DOC18/214202-02  
SSD 8707

**SSD 8797 – IVANHOE ESTATE REDEVELOPMENT CONCEPT PLAN – ENVIRONMENTAL  
IMPACT STATEMENT (EIS)**

## ATTACHMENT A

#### IVANHOE ESTATE REDEVELOPMENT – CONCEPT PLAN

## Appendix 6- Unattended Noise Data of Location 6

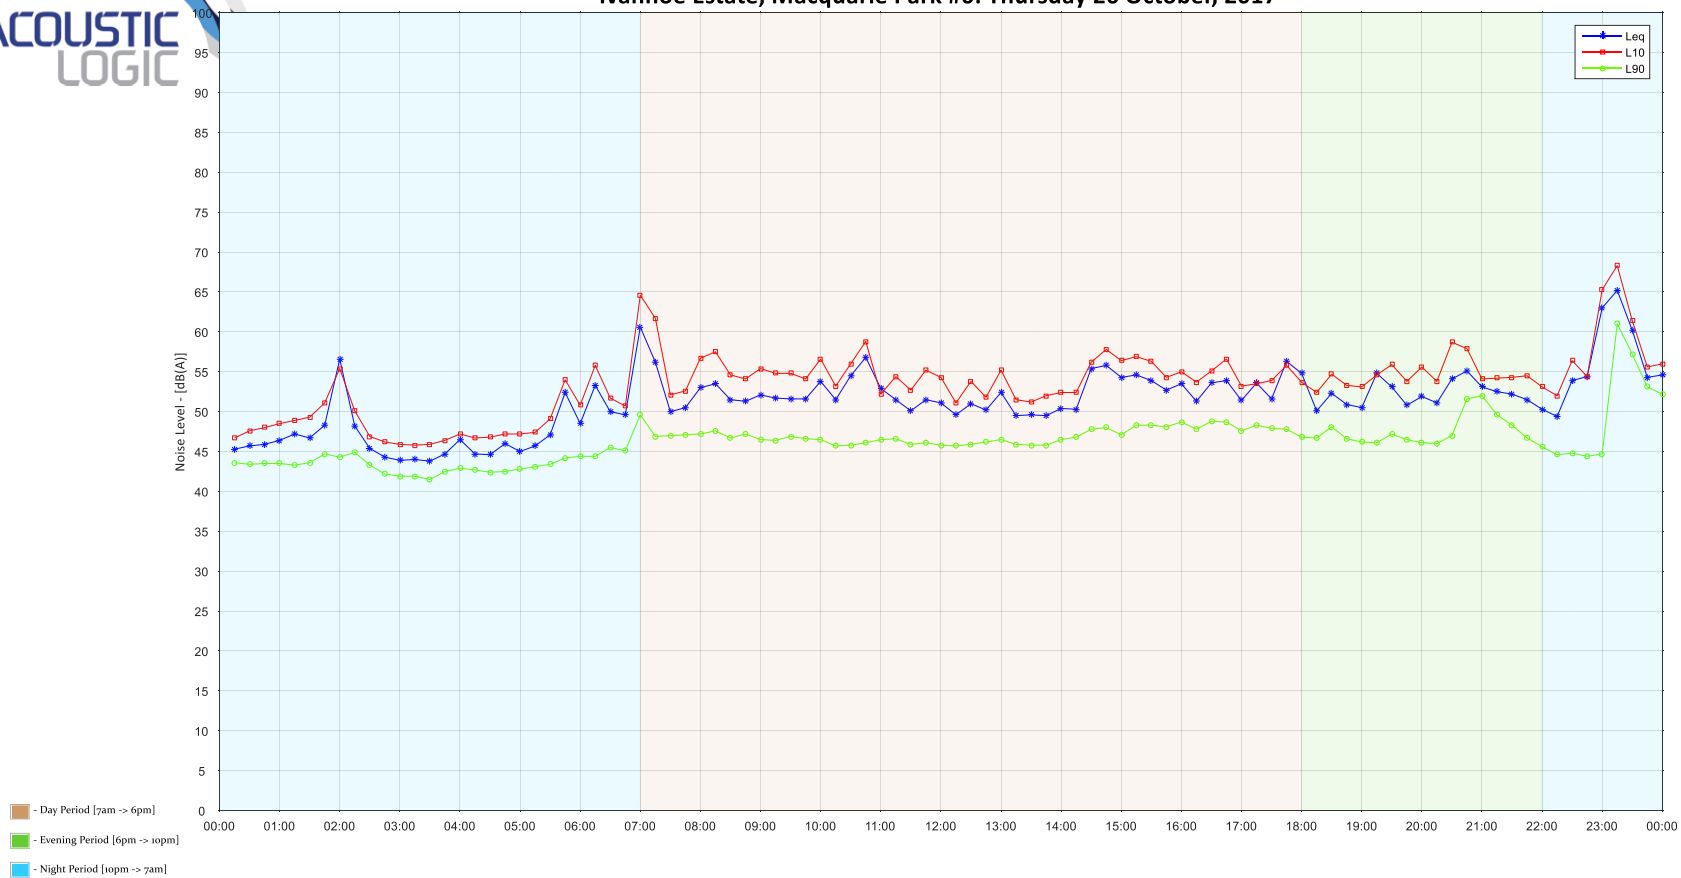
The graphical presentations in Appendix 2 to the report indicate that noise measurements at Location 6 were dominated by an extraneous noise source, which is not discussed in the text of the document other than Table 9 which references the results as 'operational noise from neighbouring commercial sites'. The results of the measurements at Location 6 should not be relied on unless the proponent provides further information that satisfactorily demonstrates they are representative of background levels.

The proponent be required to establish background noise levels in accordance with the NSW Noise Policy for Industry, in order to adequately assess potential construction and operational noise and vibration impacts on sensitive receivers and set appropriate performance objectives.
